FOUR POINTS BY SHERATON REDEVELOPMENT

BUILDING CODE OF AUSTRALIA 2014 REPORT

CAPABILITY STATEMENT FOR SECTION 96 SUBMISSION RELATING TO TWO ADDITIONAL COMMERCIAL FLOORS

Report Ref: 13-201121_FourPointsRedev(S96)_BCACapStatReport_R02_13032015

Drawing Title  
LEVEL 16 TO LEVEL 24  
TYPICAL COMMERCIAL LEVEL PLAN  
Drawing Number  
A-DA-0209  
Scale  
1200 @ A0  
REV.  
S

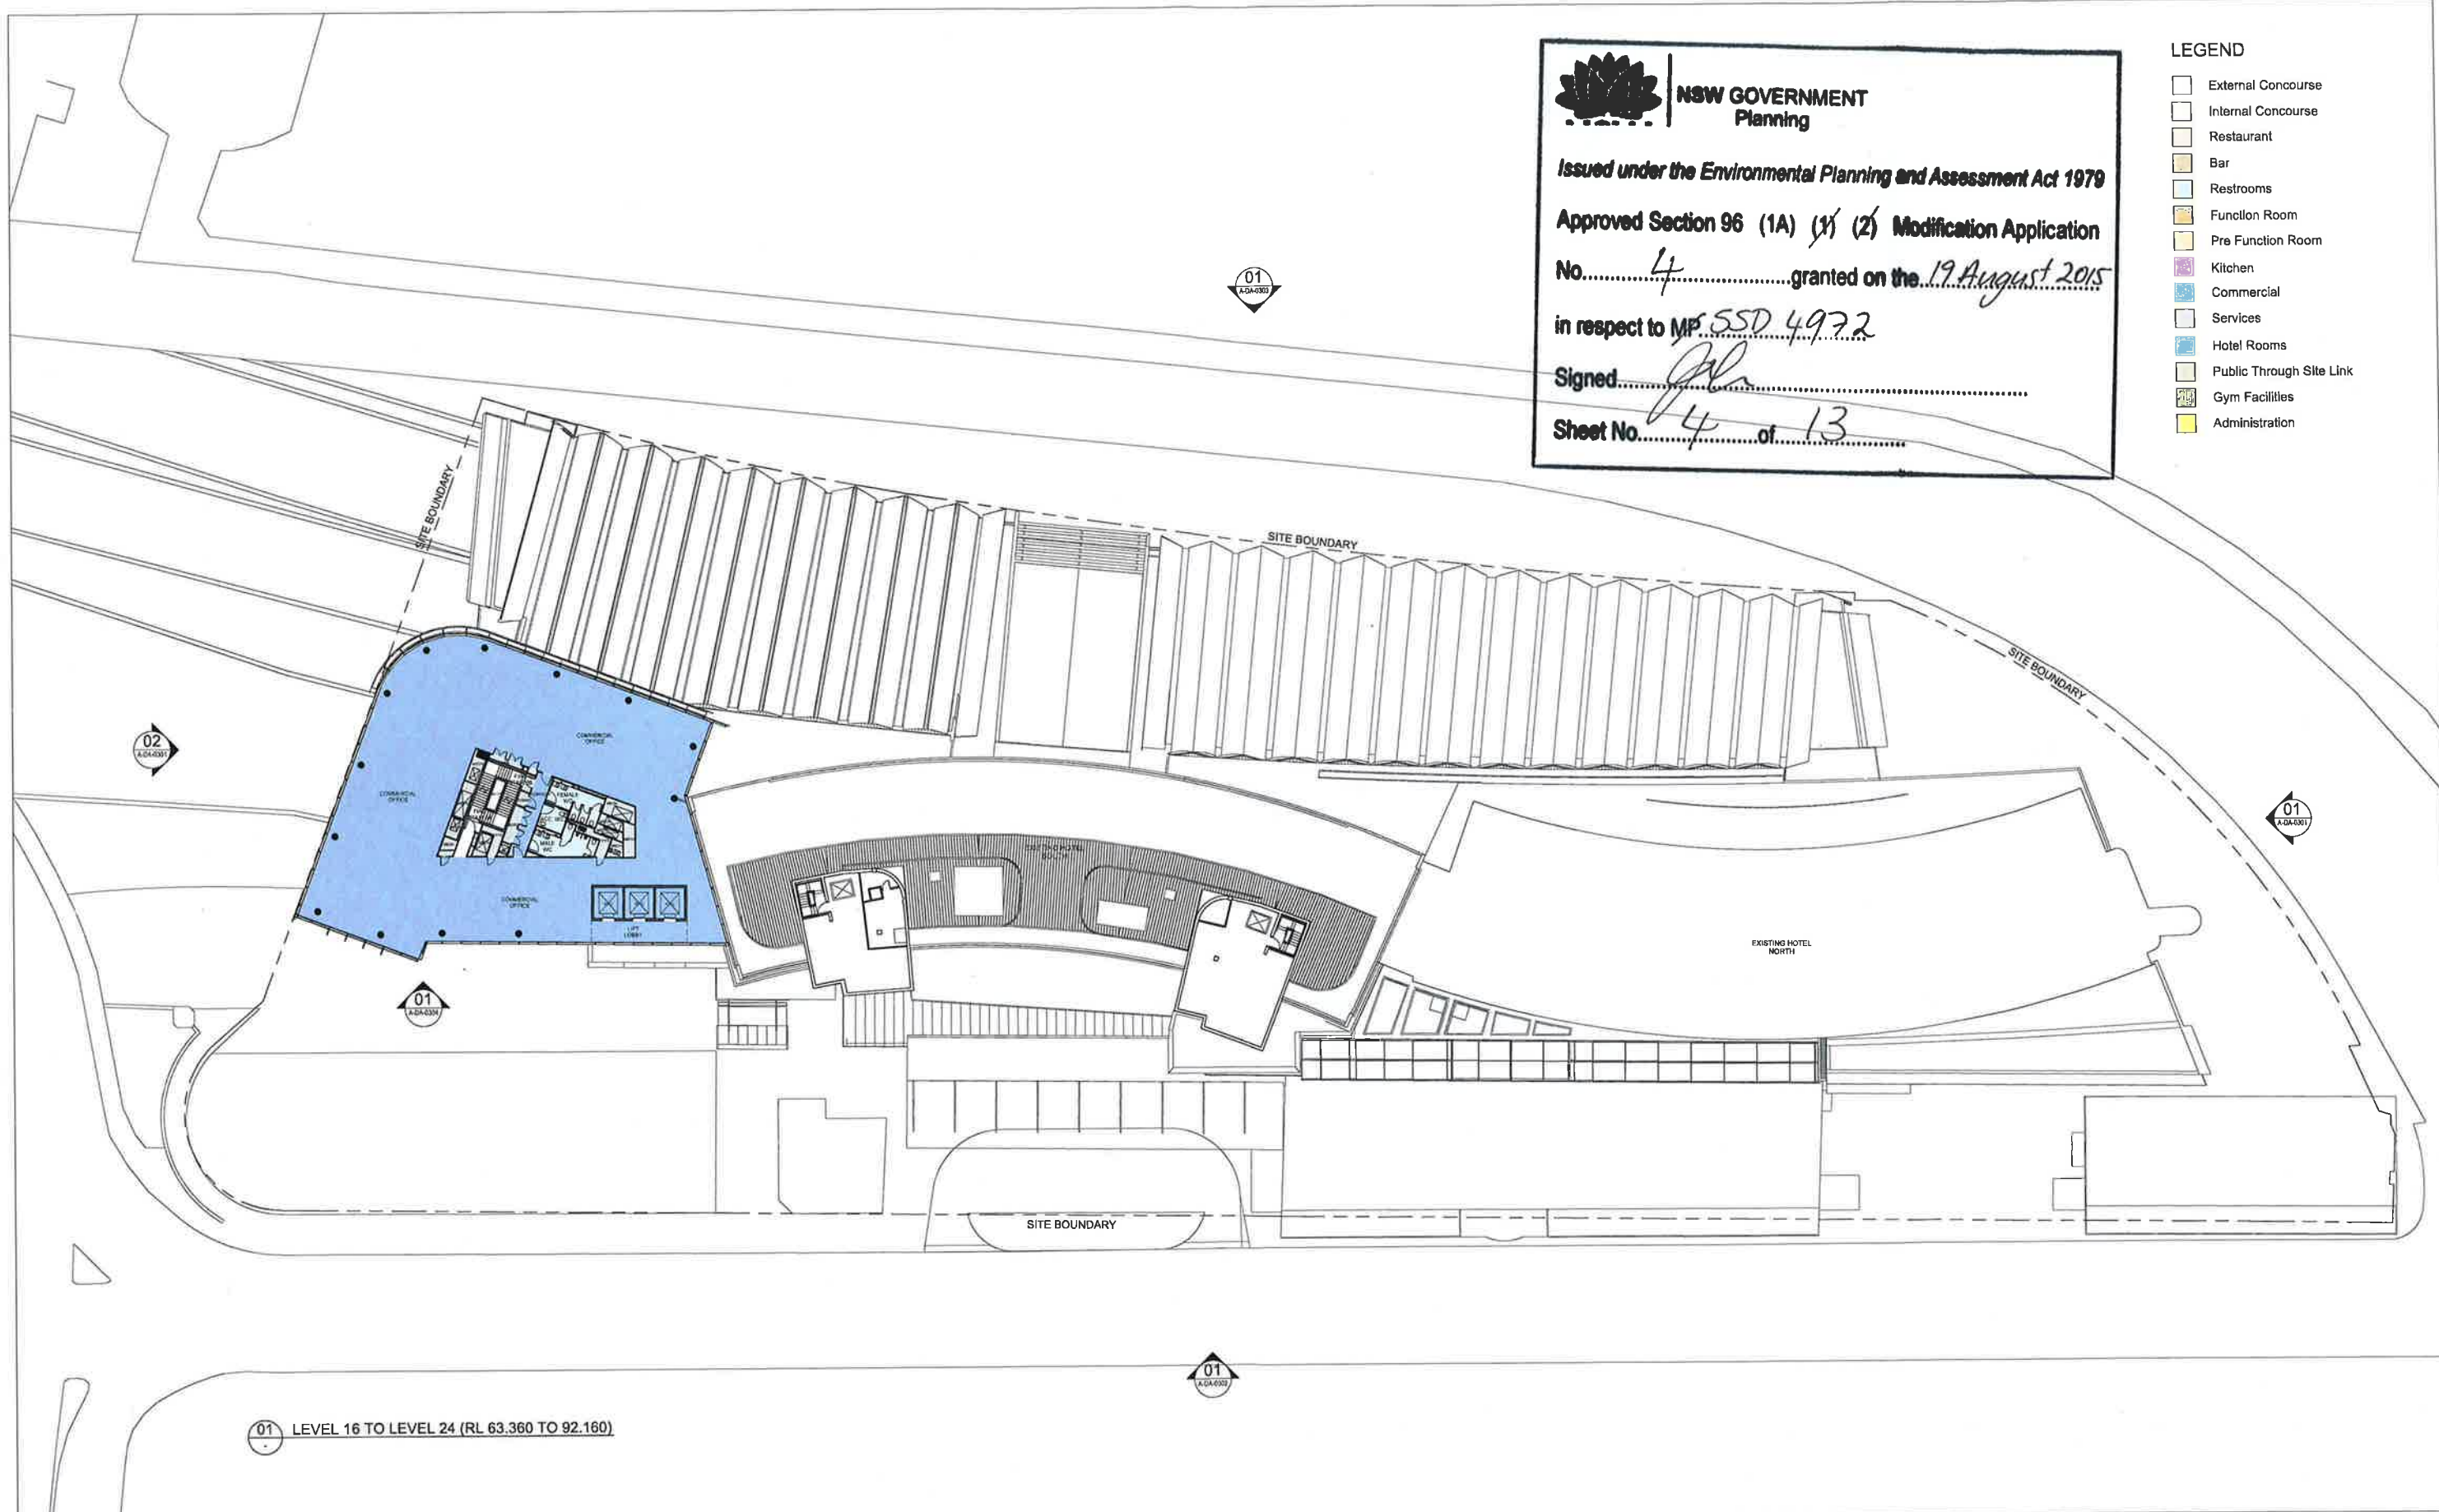
The structural slabs and columns to the Class 5 commercial offices on Levels 16-24 must be not less than 120/120/120 FRL throughout
